CITY OF ALBUQUERQUE PLANNING DEPARTMENT March 19, 2014 **DRB** Comments

PROJECT # 1002201

APPLICATION # 14-70070

RE: Lot 21-A, Block 10, North Albuquerque Acres Tract A, Unit B

SHEET TITLE
 AMENDED SITE DEVELOPMENT PLAN FOR BUILDING PERMIT

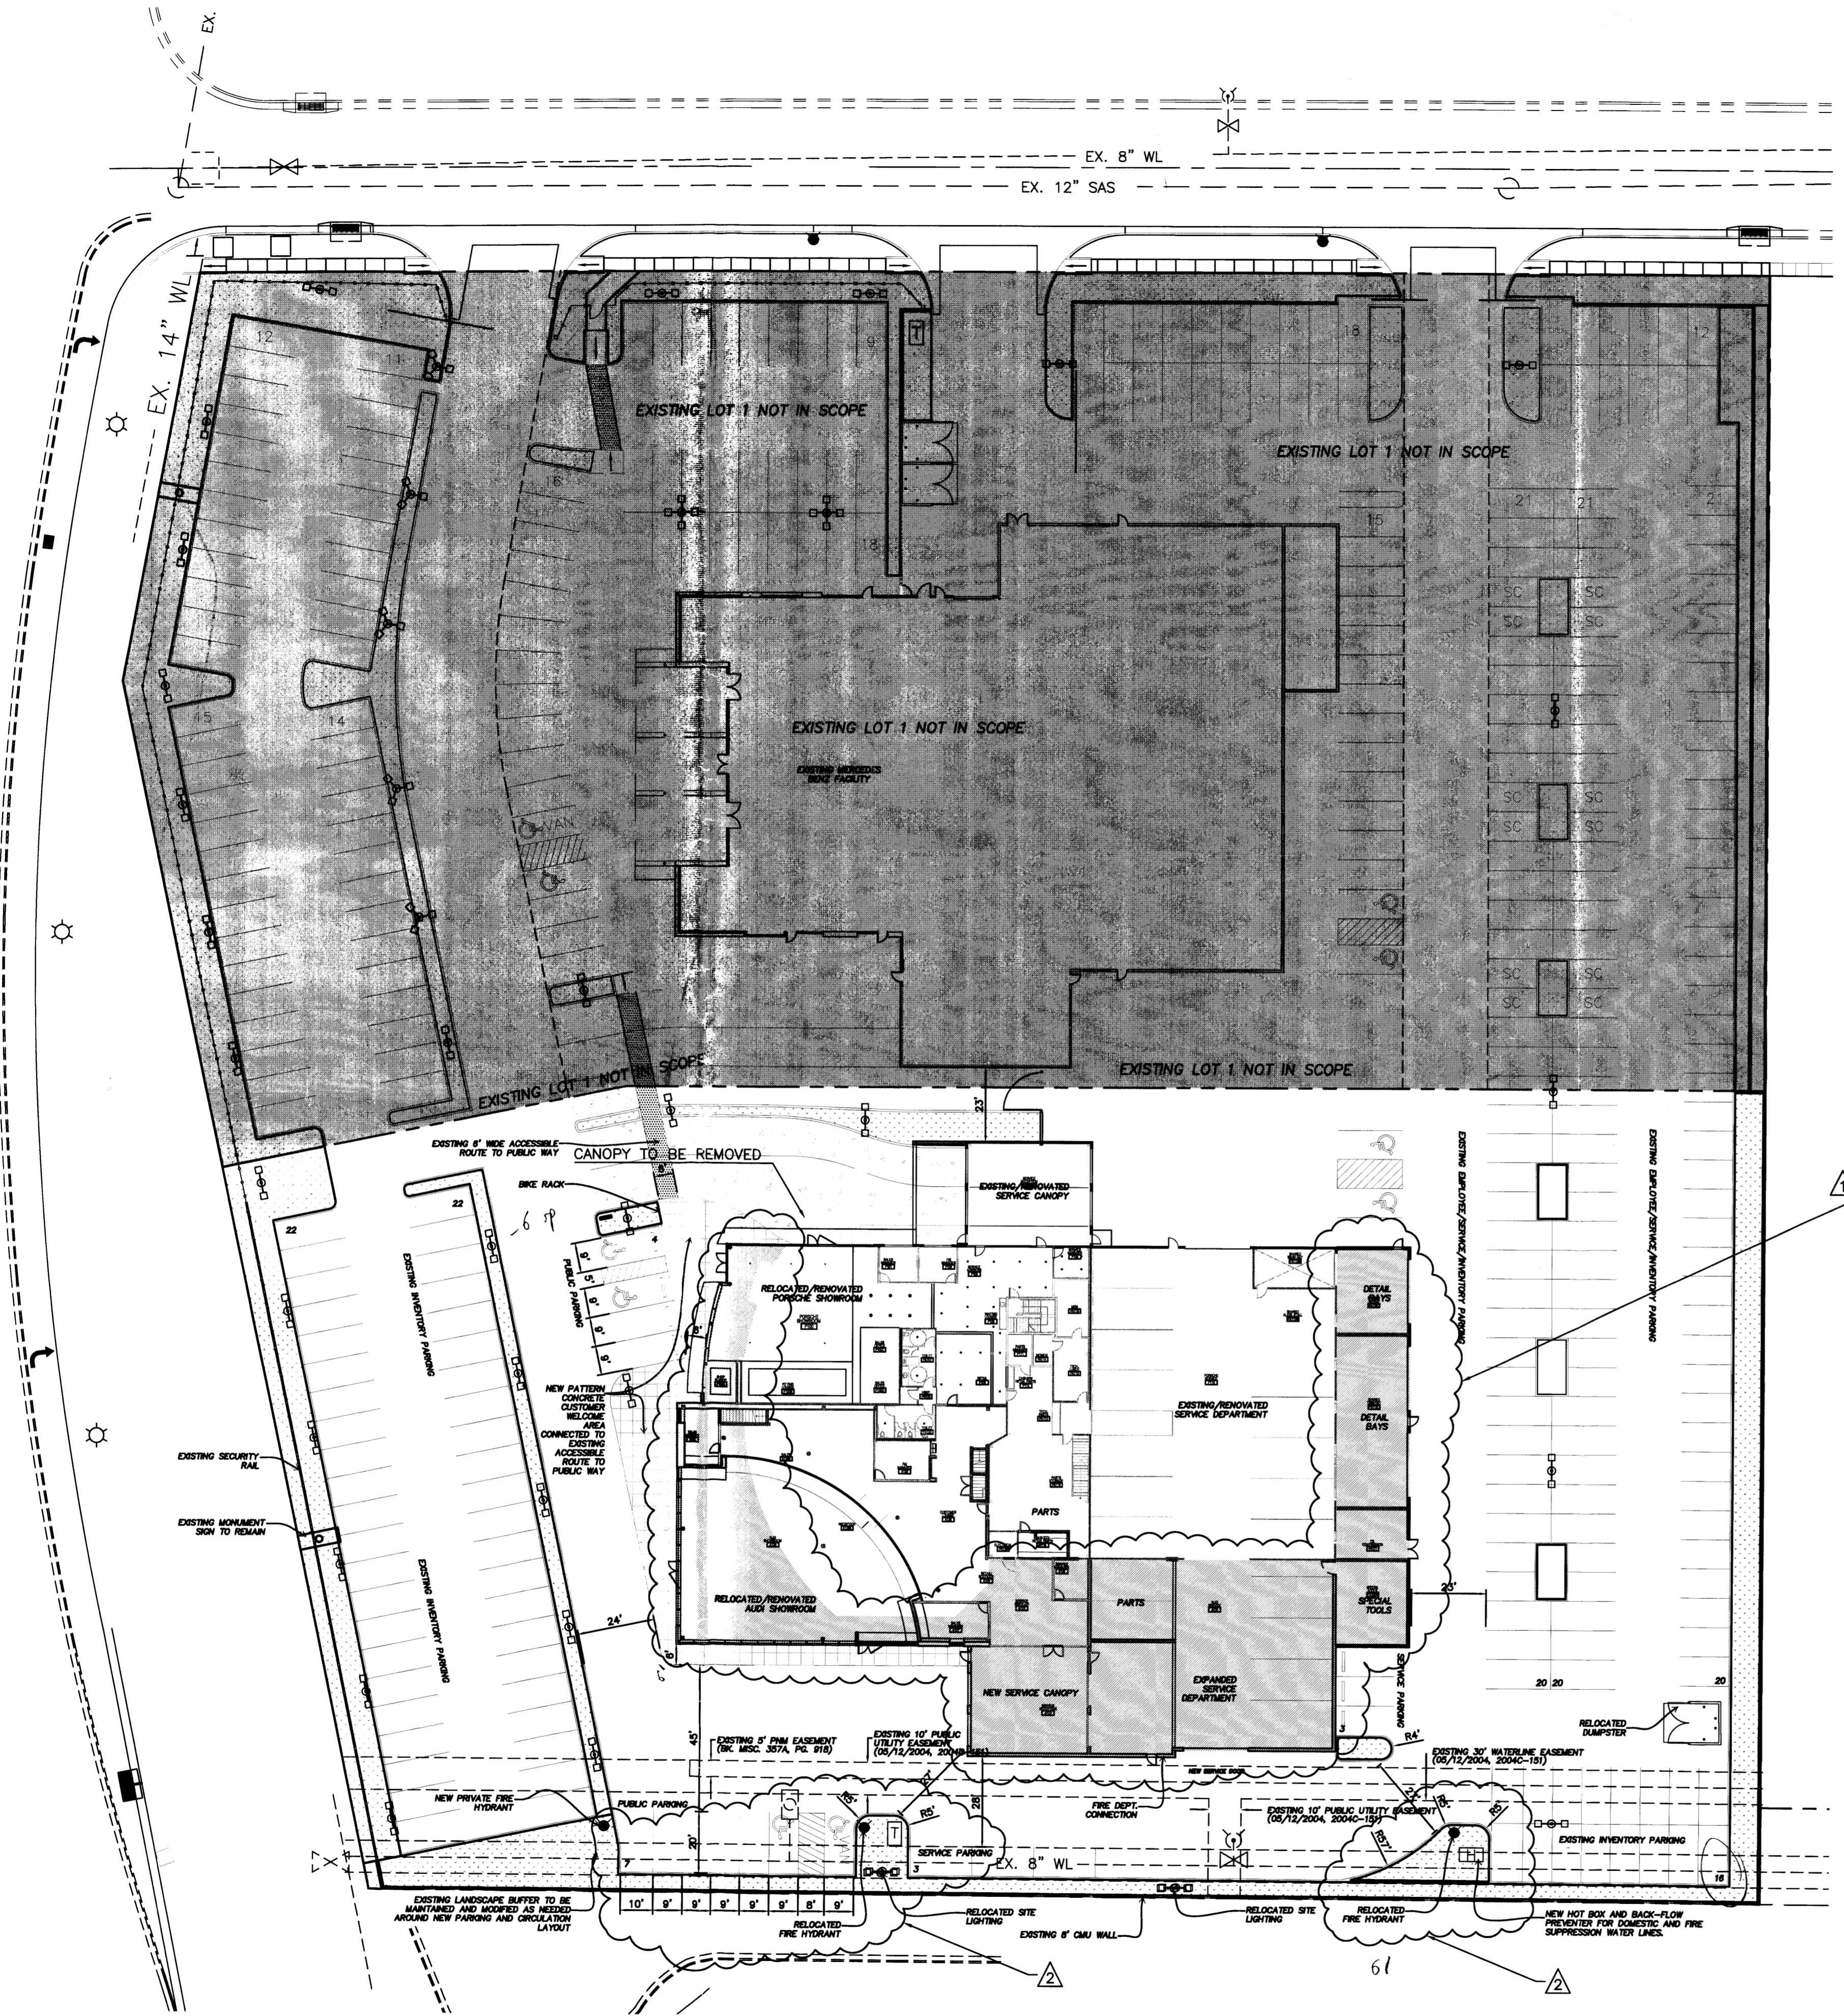
'Tandem' parking spaces cannot be counted for required parking; the 16 spaces in the SE corner may only be counted as 8, and the parking table needs to be adjusted accordingly.

01 LANDSCAPE PLAN

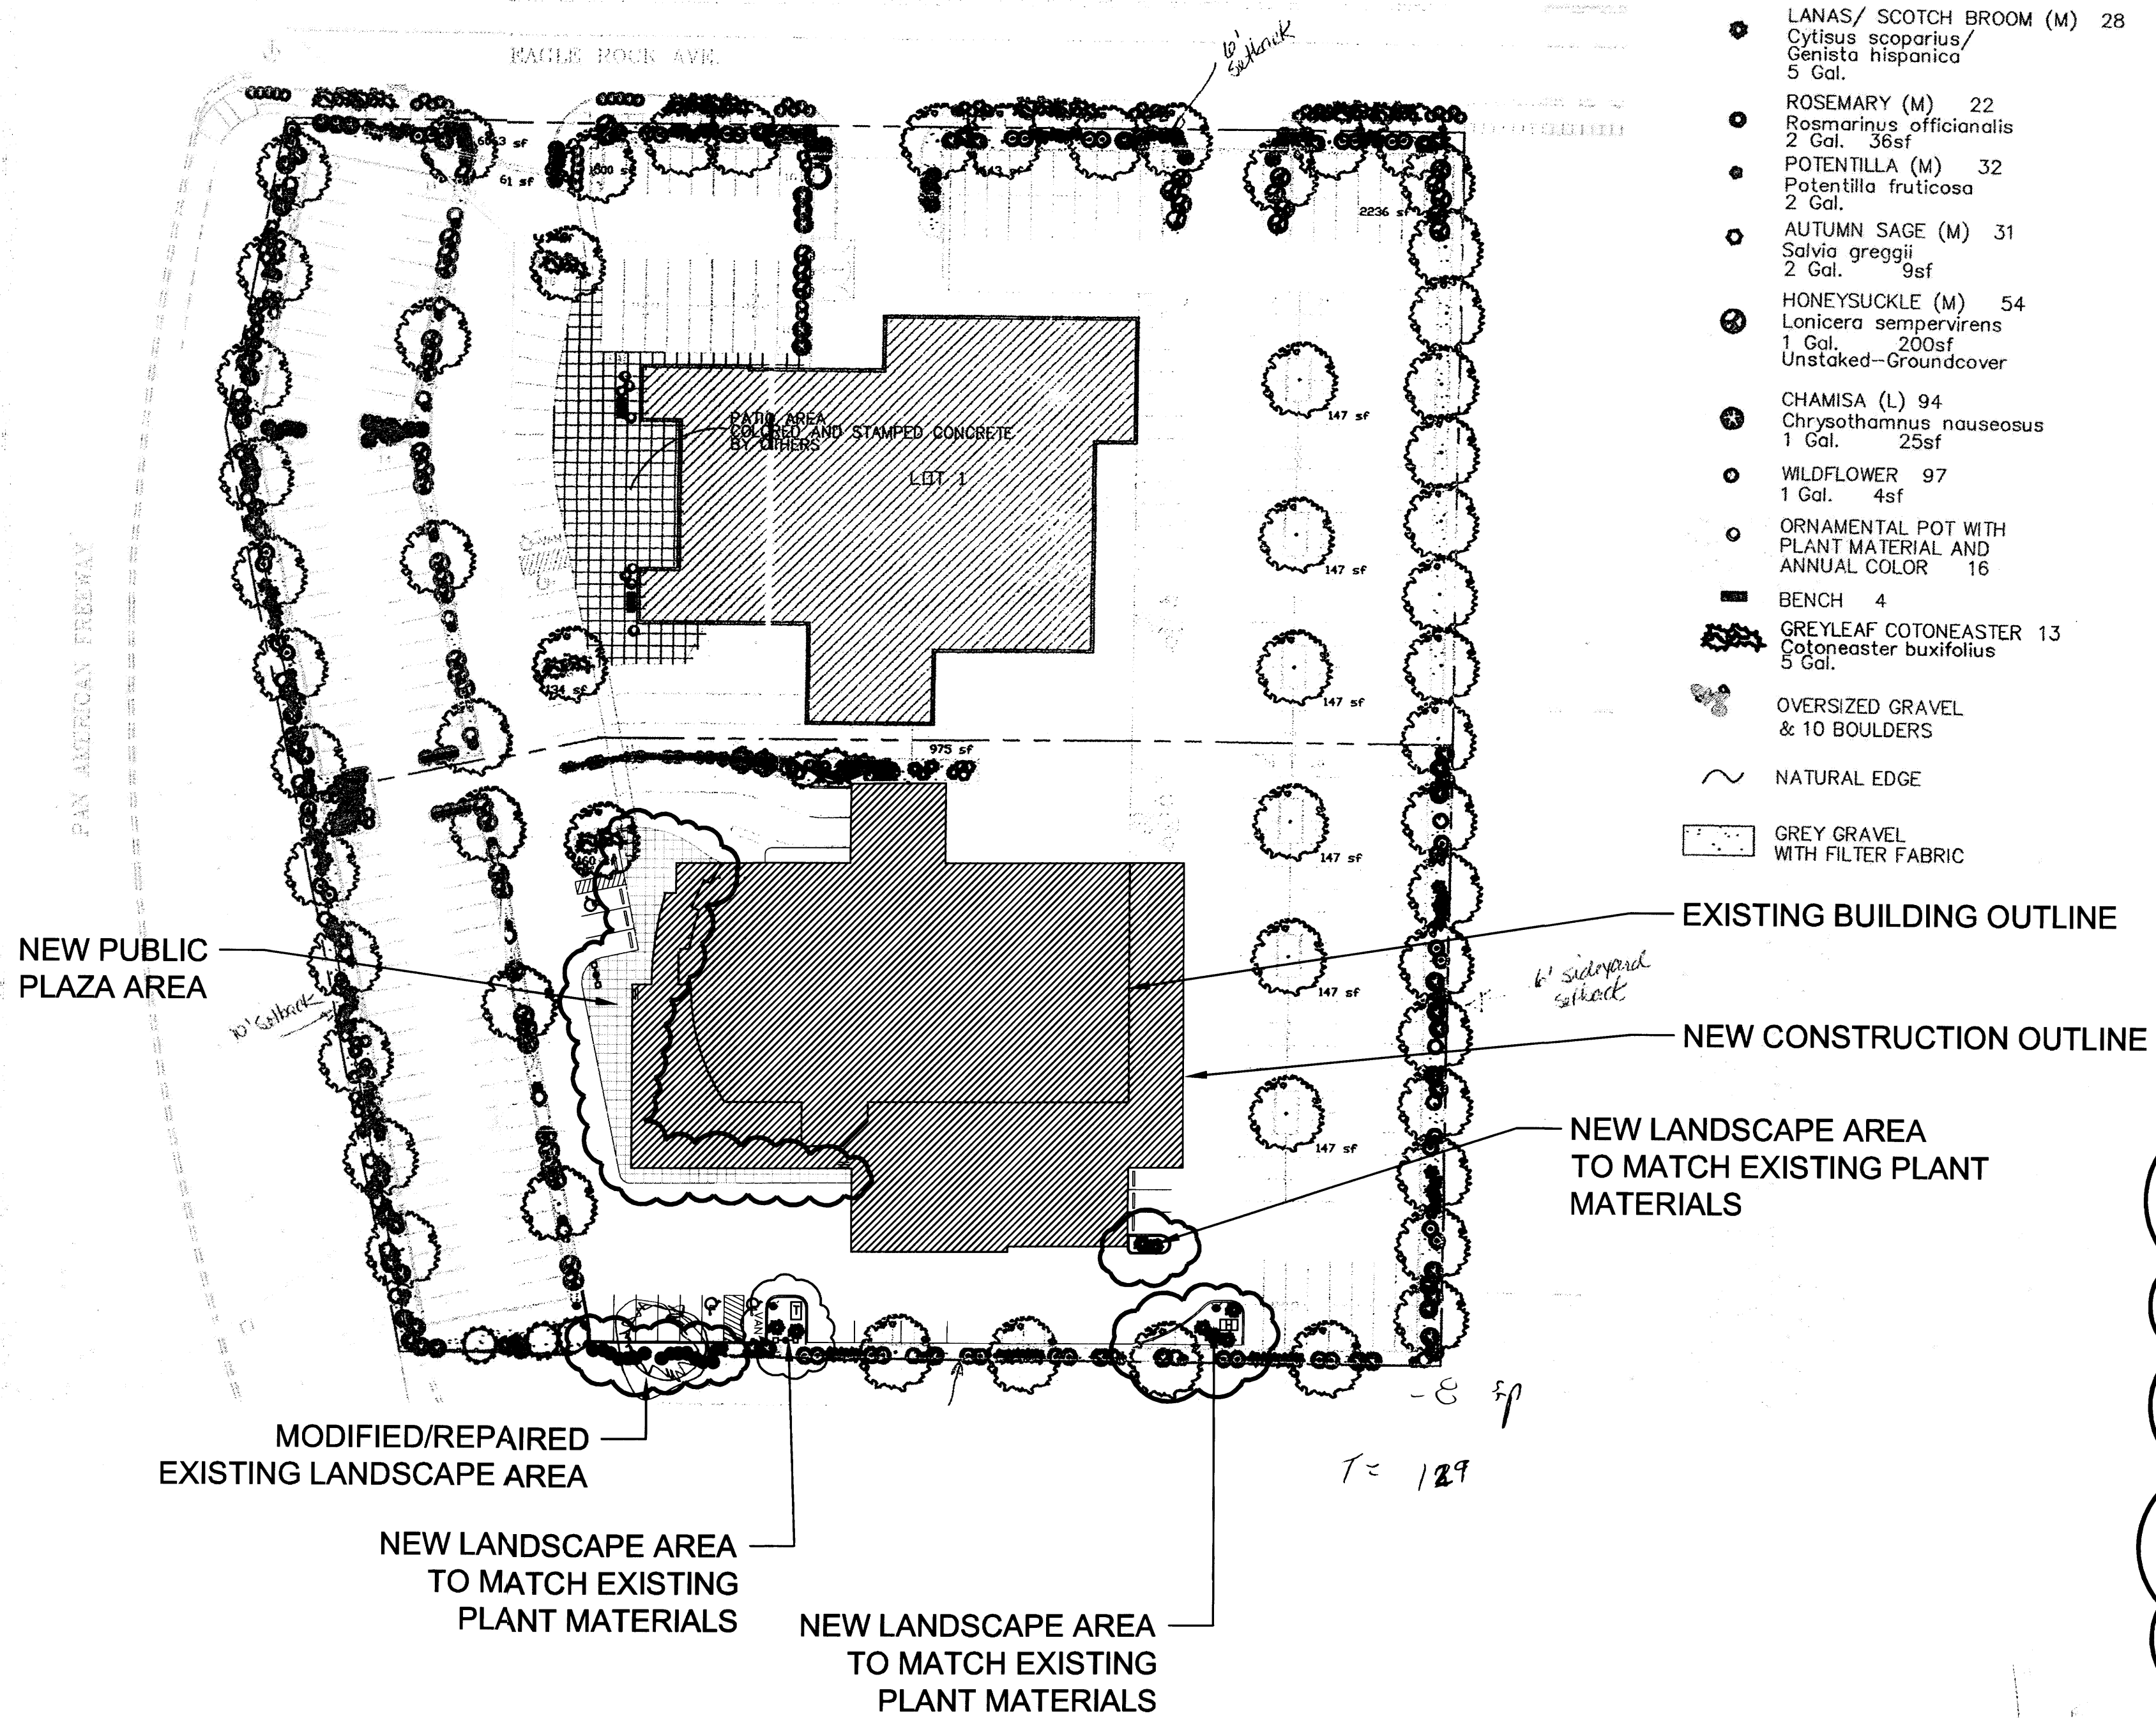
Some additional landscaping is needed in new patio area similar to the tract on the north side, and an additional tree is needed along the south border. The site plan needs to be reviewed and initialed by David Kilpatrick, Zoning Enforcement, for compliance with the Zoning Code and North I-25 Sector Plan.
